**From:** Rich Elliott <elliotttr@kvfr.org>  
**Sent:** Friday, February 13, 2015 10:14 AM  
**To:** Kaycee Hathaway  
**Cc:** Brenda Larsen; Joe Seemiller; John Sinclair  
**Subject:** RE: Notice of Application: AU-14-00004 Anderson

**From:** Kaycee Hathaway [<mailto:kaycee.hathaway@co.kittitas.wa.us>]  
**Sent:** Wednesday, February 11, 2015 8:10 AM  
**To:** Brenda Larsen; Holly Myers; Christina Wollman; Rich Elliott; Dr. Paul Farris, Ellensburg School District  
**Subject:** Notice of Application: AU-14-00004 Anderson

ENLARGED SITE PLAN

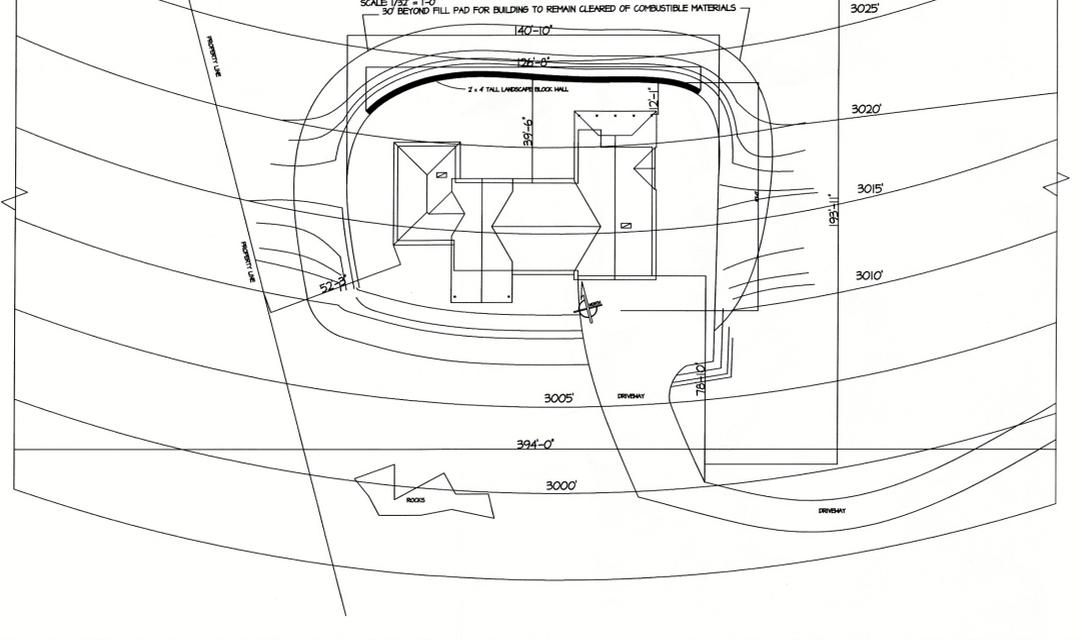
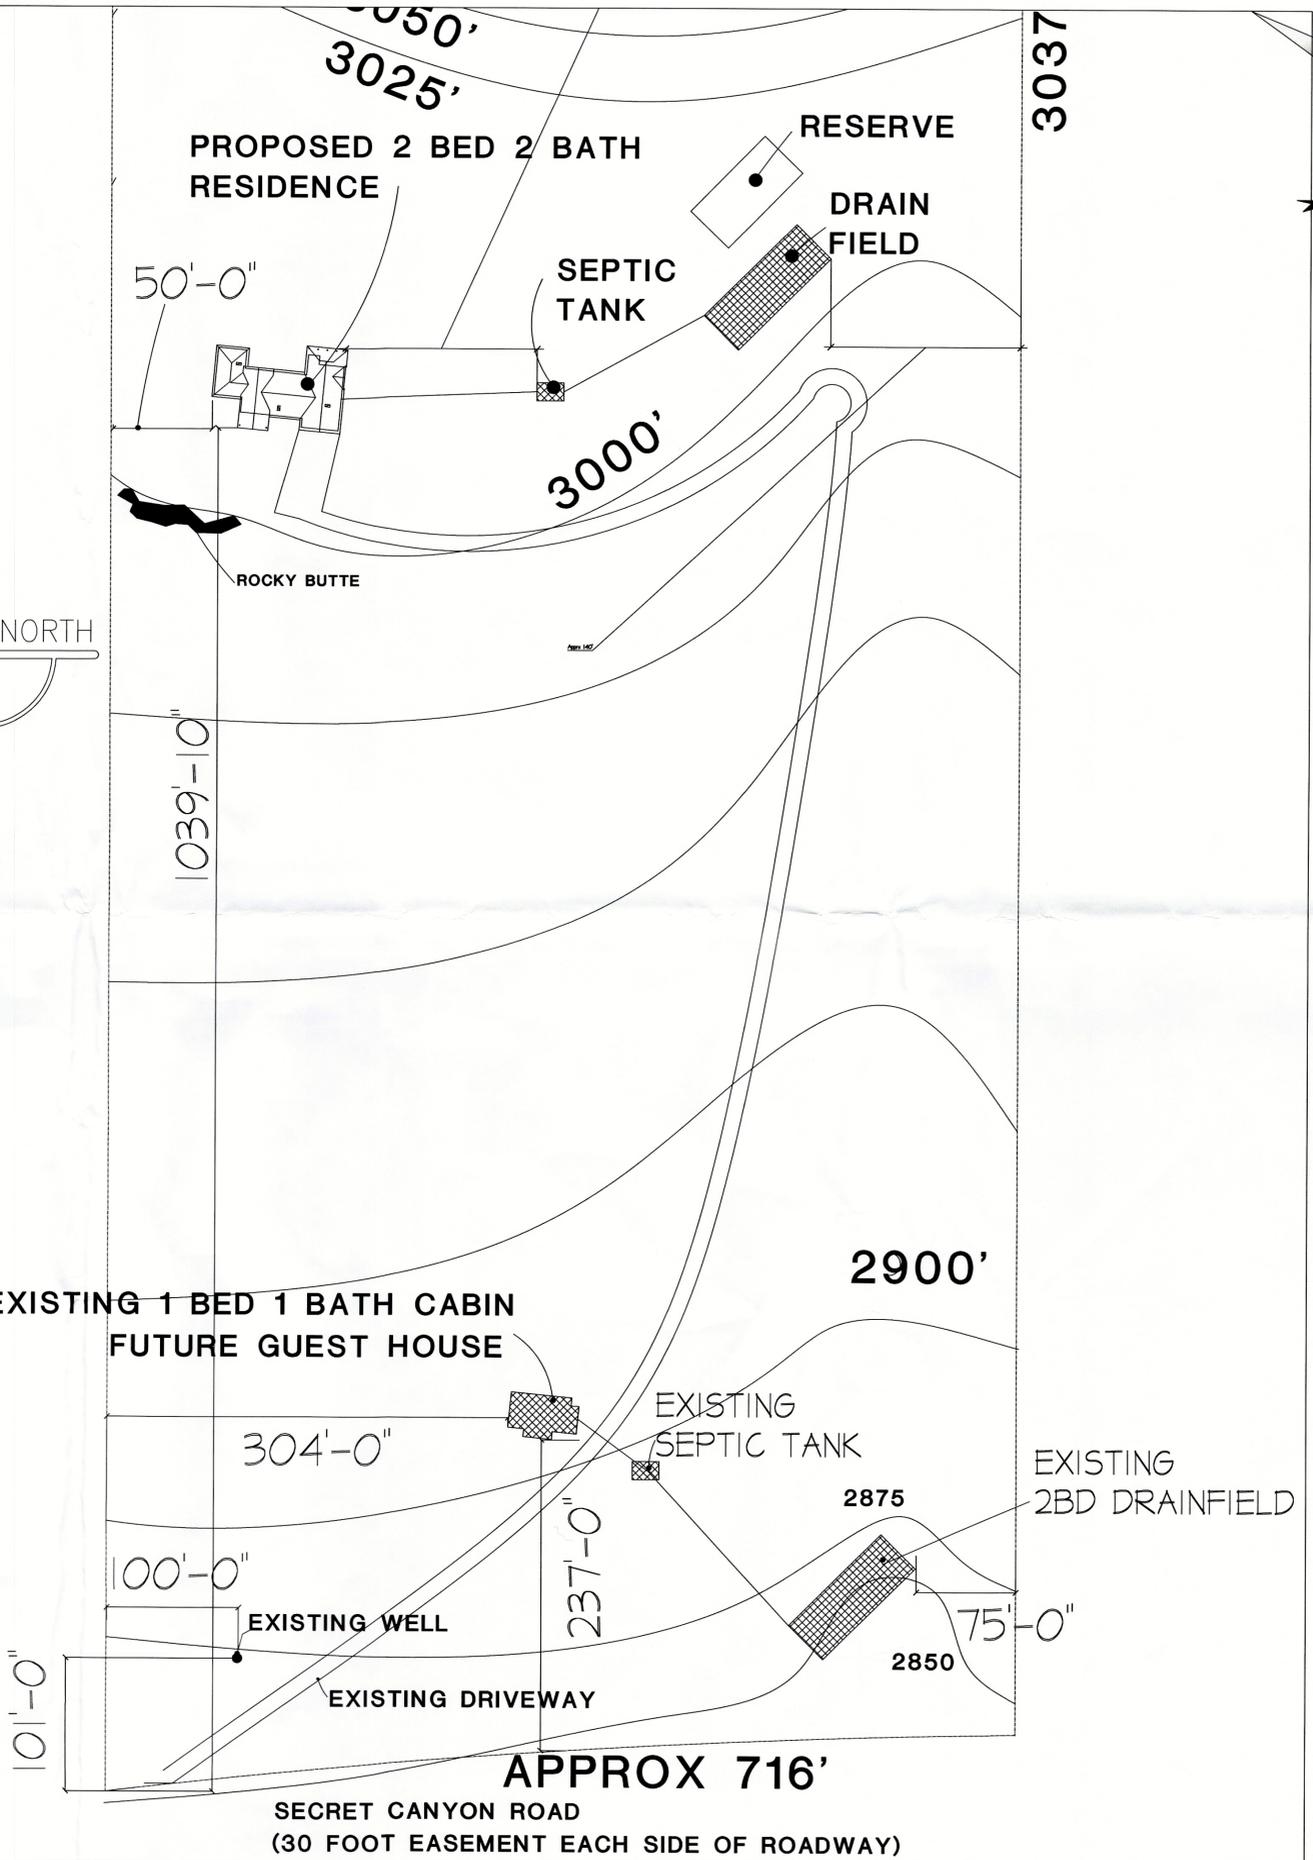
This project is in an area subject to wild land interface fires. I would anticipate that the WUI code would apply to the current use and for the proposed addition. Response time to this location for fire resources exceeds any reasonable expectation that a structure would be saved. Encourage consideration of fire sprinklers.

ADU to be addressed clearly for fire and EMS response.  
Access to conform to IFC 1012 – Appendix D
